MECKLENBURG COUNTY  
Park and Recreation Department

MEMORANDUM

**RE:** Rezoning Petition #2020-12 – Edgewood Preserve

SHEET NUMBER
RZ-1

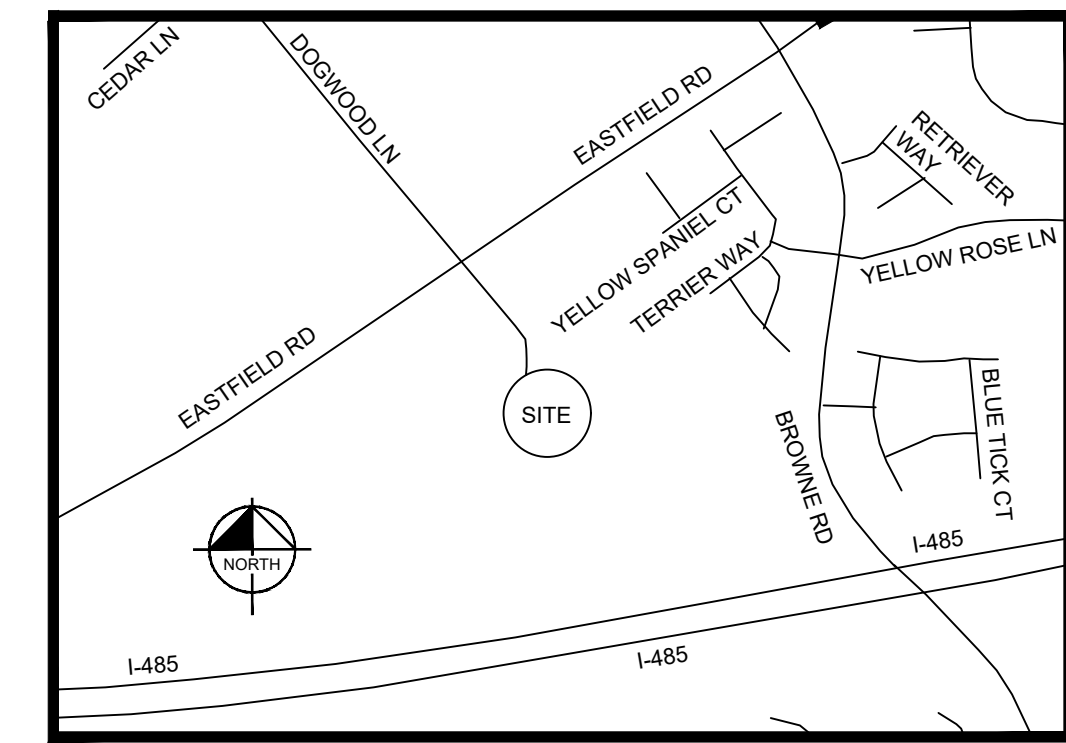
MCPR requests the petitioner consider dedicating and conveying to Mecklenburg County a minimum 2-acre parcel for a future Neighborhood Park outside of the stormwater facilities and have access to a public right-of-way. This petition is in a gap area for public open space. We would be happy to discuss in further detail upon request.
